RHETORIC SELF STORAGE FACILITY
LETTER OF INTENT
SITE DEVELOPMENT PLAN – MINOR AMENDMENT
APPROVED SDP - EPC PLAN NO. PPR2524
May 19, 2026

Matrix Design Group, on behalf of Colorado Concrete Crushing LLC, is submitting a Site Development Plan-minor amendment for a shipping container self-storage facility located on Lot 1 of the Sterling Recycling Subdivision.

SP01

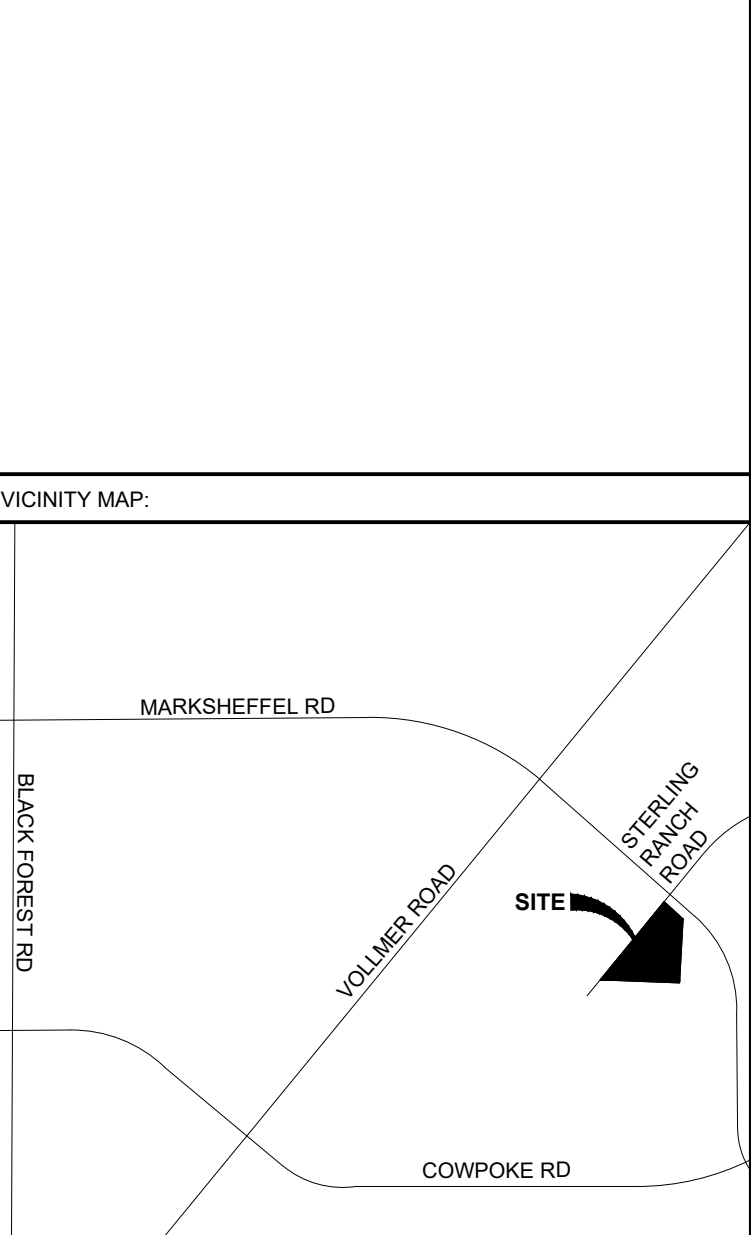
- Adjustment of the storage container layout to accommodate a consistent size storage container of 8'x20'. 24' min. drive aisles are maintained, building setbacks, landscape buffers, and the overall gravel footprint remains the same. The detail sheet was also updated to illustrate the storage container size

TS01

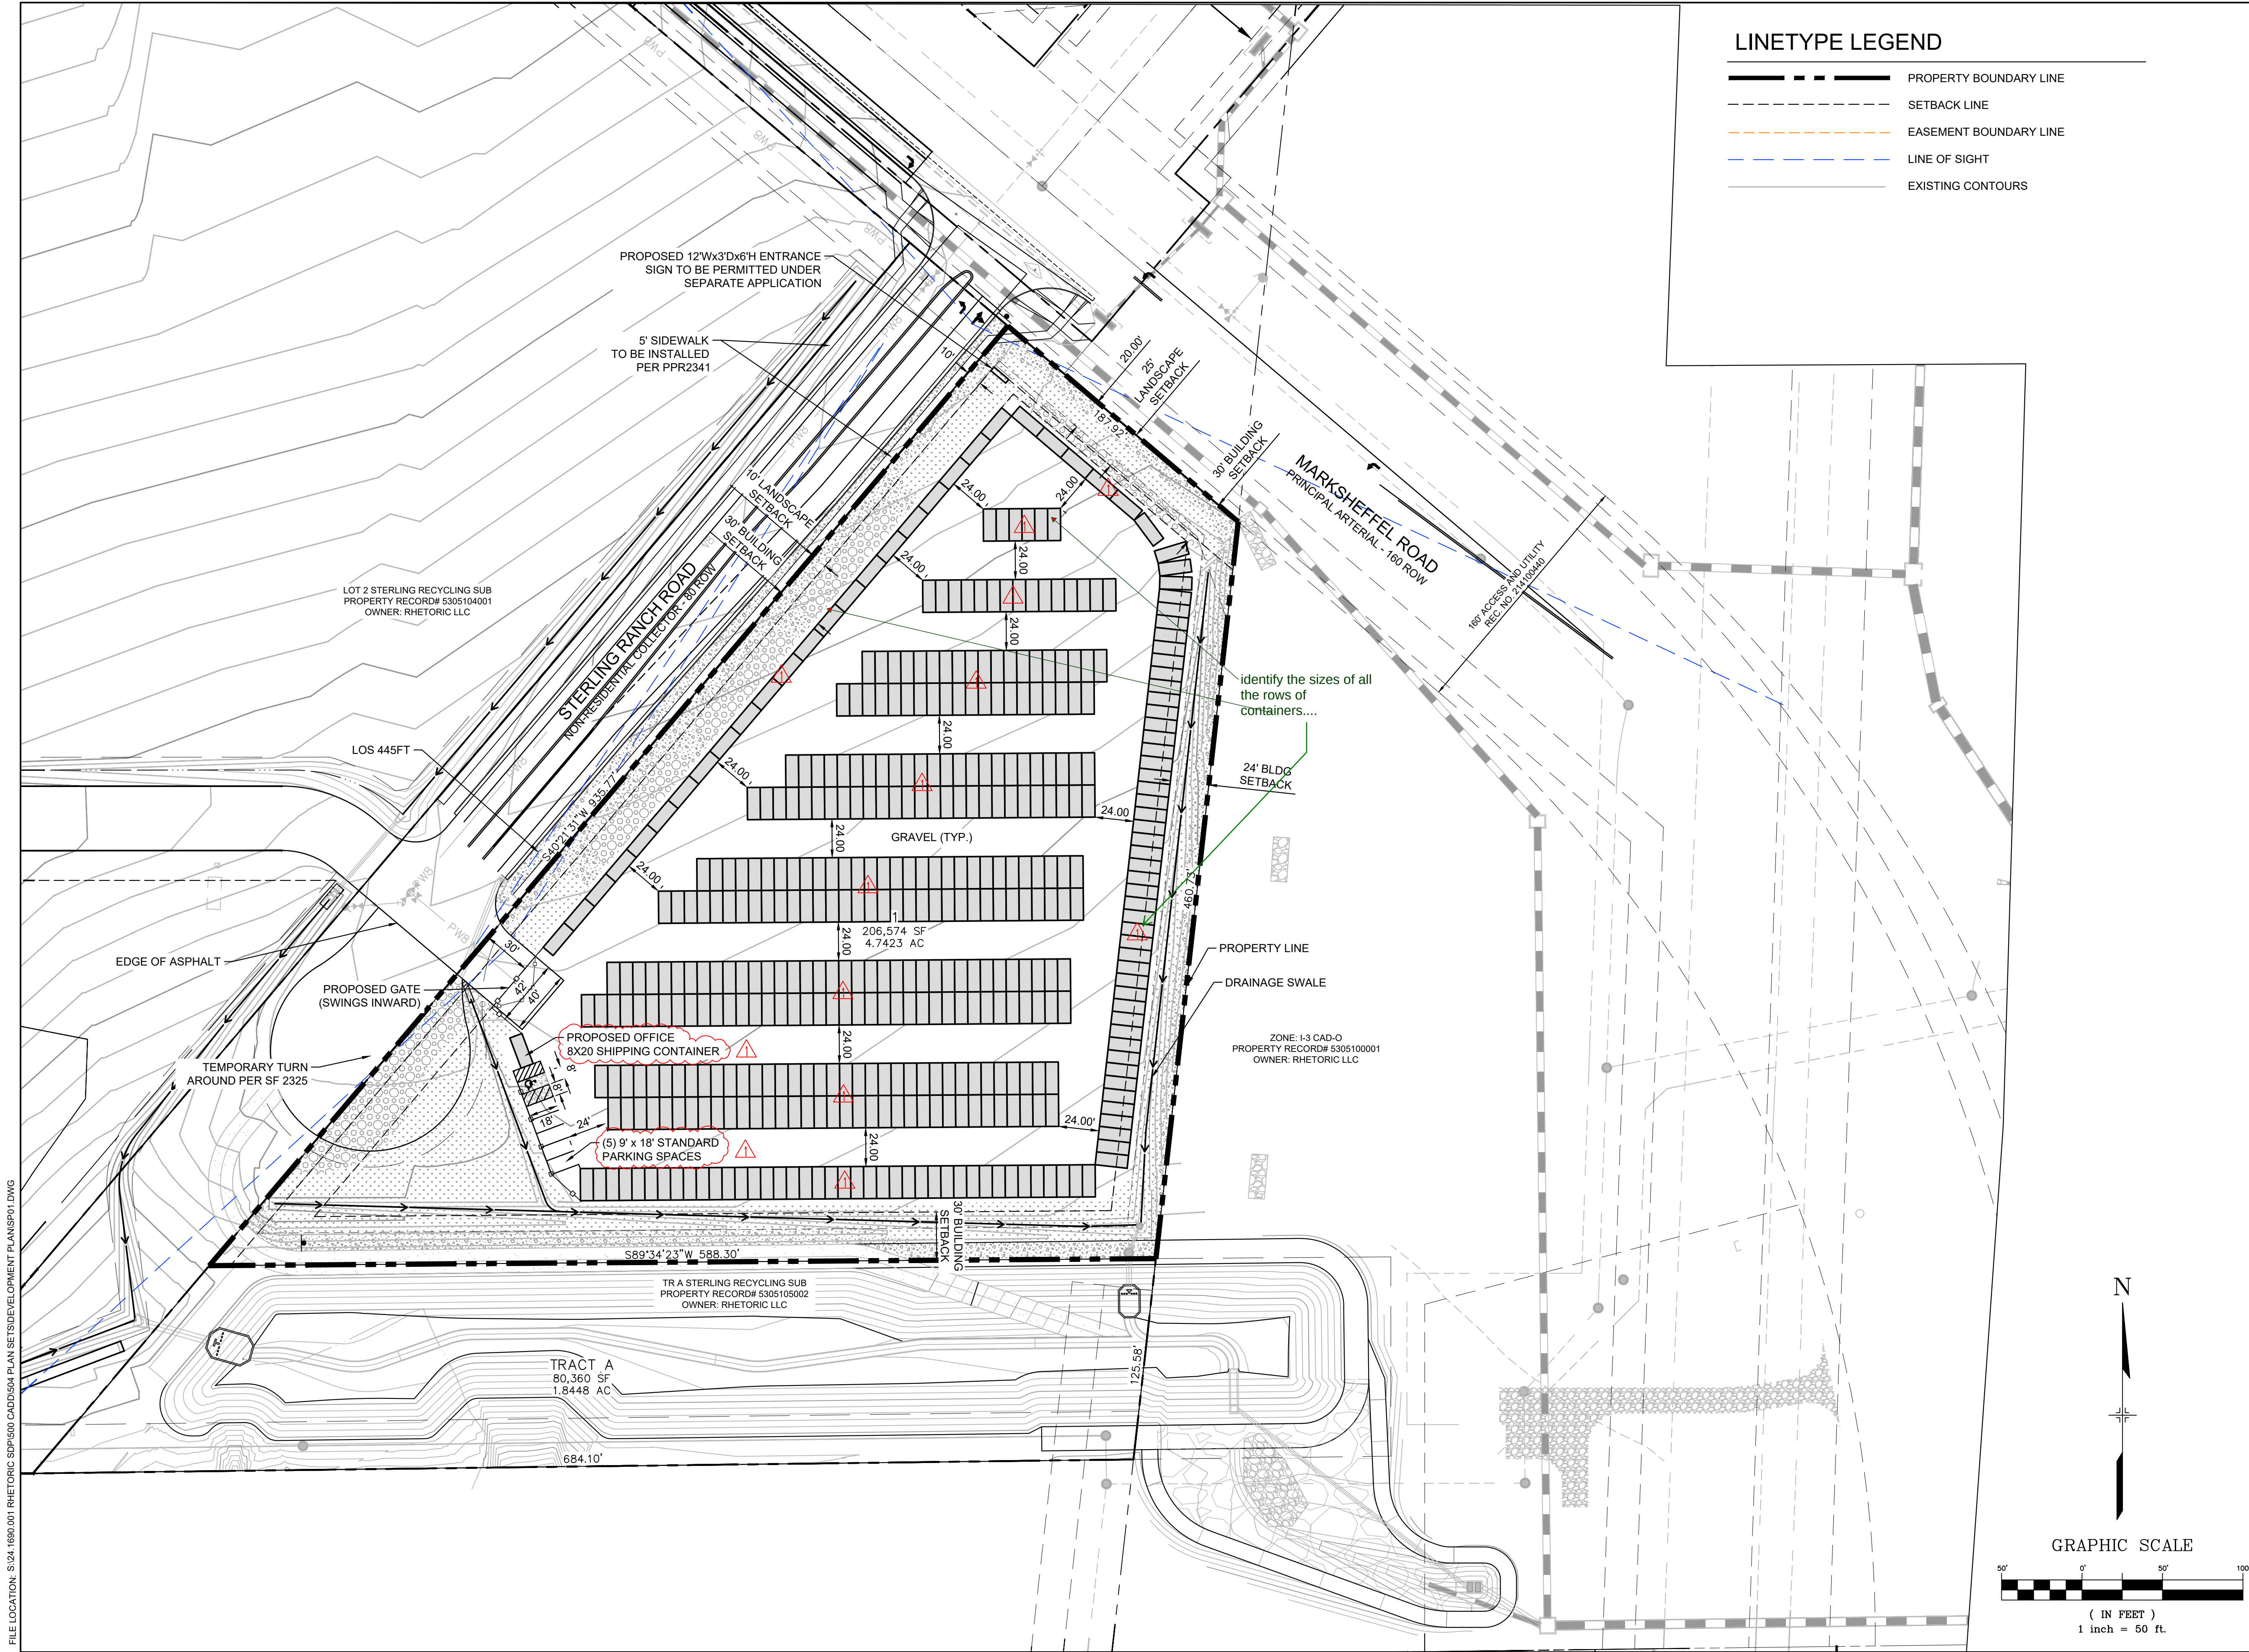
and the total number of storage building square footage the elevations remove the 8 x 10 and 8 x 40 units all together and depict 8x 19.5' that indicates an increase in square footage- is that correct?

- Matrix response: The unit count goes up because you can fit many more of the 8'x20' units and previously a majority of the units were 8'x40'. The smaller size units increase the overall unit count but decrease the overall square footage. I have attached an exhibit as page 7 of this redline that shows the current layout and the original layout shown in red. The overlay depicts that the original layout storage units covered more of the site but now the layout is less storage unit and more drive aisle area (although contained within the same overall footprint).

Matrix response: The 8x10 and 8x40 units are not available and have been removed from the plan. All units are now the Boxwell 8'x20' (160 sq. ft.) self-storage units.

decreased to 69,760.
